# Appeal Decision

**Appeal Ref: APP/R5510/W/23/3314225**

**71 Thornhill Road, Ickenham, Hillingdon, UB10 8SH**

- The appeal is made under section 78 of the Town and Country Planning Act 1990 against a refusal to grant planning permission.
- The appeal is made by Miss Sharma against the decision of the London Borough of Hillingdon.
- The application Ref 64731/APP/2022/2744, dated 1 September 2022, was refused by notice dated 28 October 2022.
- The development proposed is a replacement dwelling.

PROPOSED GROUND FLOOR PLAN
1:100

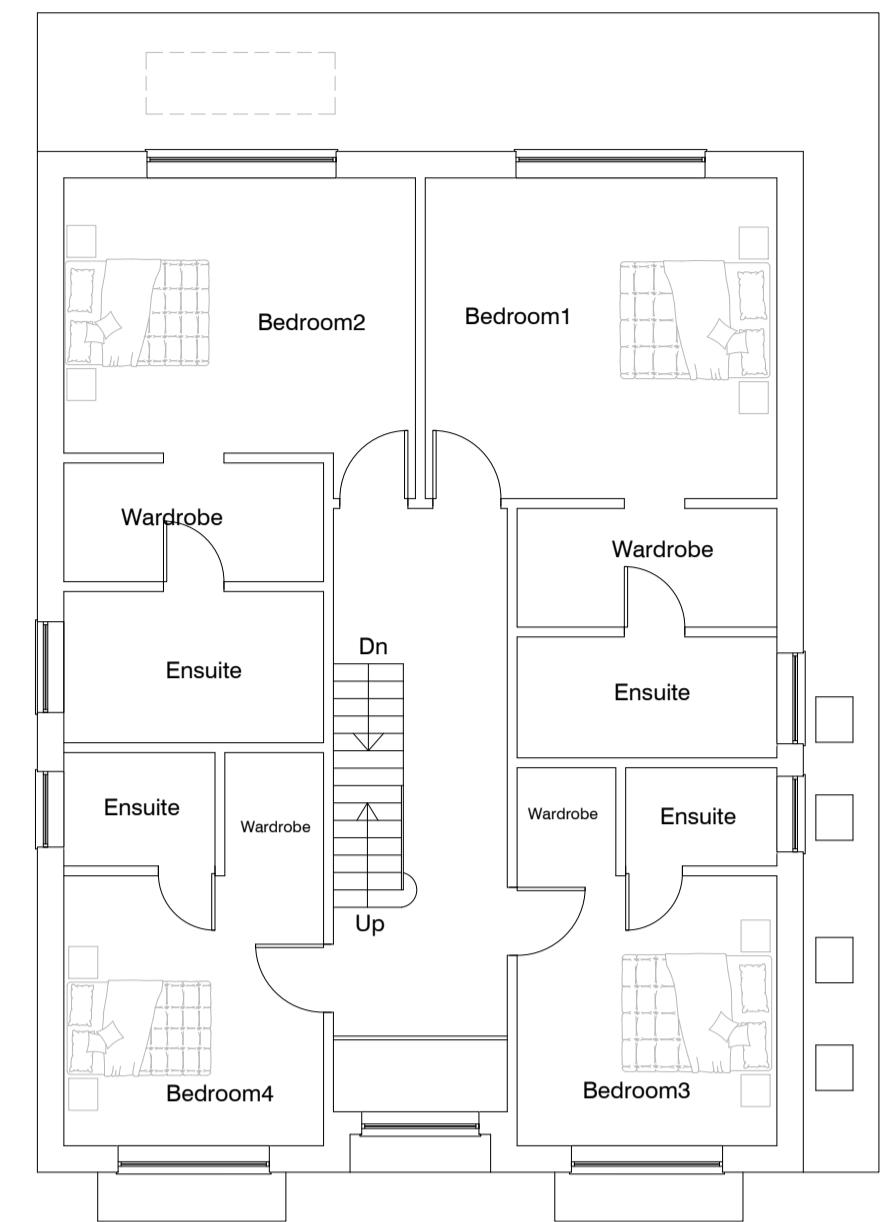
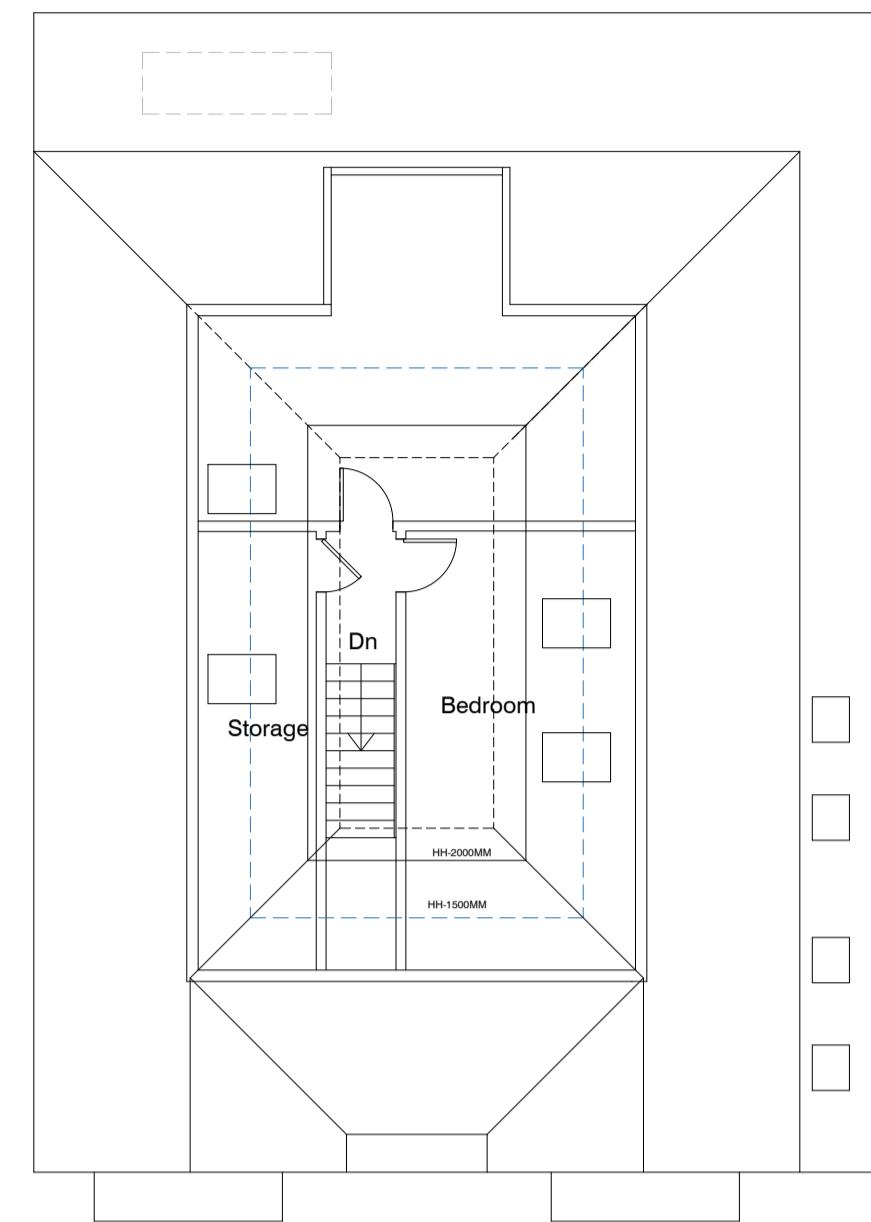
15. In respect of effect on the living conditions of neighbouring dwellings. I note that the extended No 73 is set in further than the existing rear elevation of the bungalow within the appeal site. Consequently, the proposed dwelling which would be set closer to the side boundary and extend further to the rear than the existing bungalow, would have an impact on this neighbouring property. In observing the position of windows in the rear and side of the extended No 73 and having regard to the bulk, position, and massing of the proposed dwelling, I find that the proposal would have a dominant and visually intrusive effect on the living conditions of the occupiers on No 73.

16. In respect of the neighbouring property to the northern direction of the appeal property (No 69). The proposal would project both forward of the front elevation and be set back further than the rear elevation of No 69. Also, the 2-storey element of the proposed dwelling would be close to the side boundary of No 69. As a result, due to the scale and proximity of the proposal, it would have an overbearing and visually intrusive impact, likely to cause material harm to the occupants' residential enjoyment of No 69.

PROPOSED FRONT ELEVATION
1:100

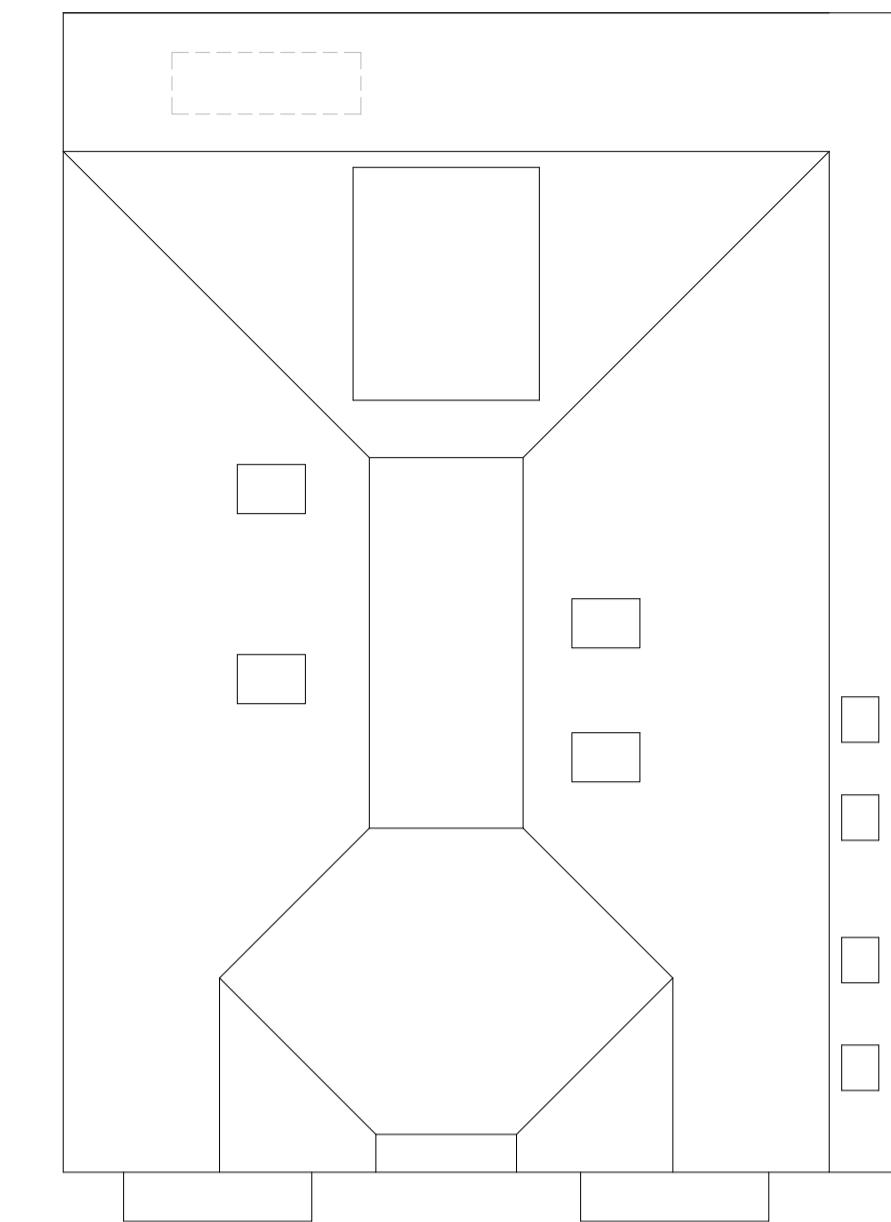
12. The proposed dwelling, in comparison, would include two front gables and bring forward the front elevation of the property beyond its existing and the neighbouring front building line. The proposal would therefore appear prominent in the street scene when compared to its immediate neighbours. Furthermore, the proposed main roof, which includes a bedroom in the roof with dormer to the rear and main crown roof design, would result in an overly large bulky roof, which would appear unduly prominent in the street scene, due

to its scale, massing, and position. This is not comparable to the roof design of the extended No 73 or other properties in the immediate area.

13. The proposed dwelling would also extend at 2 storey height closer to the side boundaries and appear much taller than the existing bungalow. This, together with other elements of the proposal, including the projection forward of the front of the building line; the gable front roof elements; and overall scale and mass of the proposed dwelling, would result in an incongruous and overly dominant feature within the street scene. This would be detrimental to the character and appearance of the area.
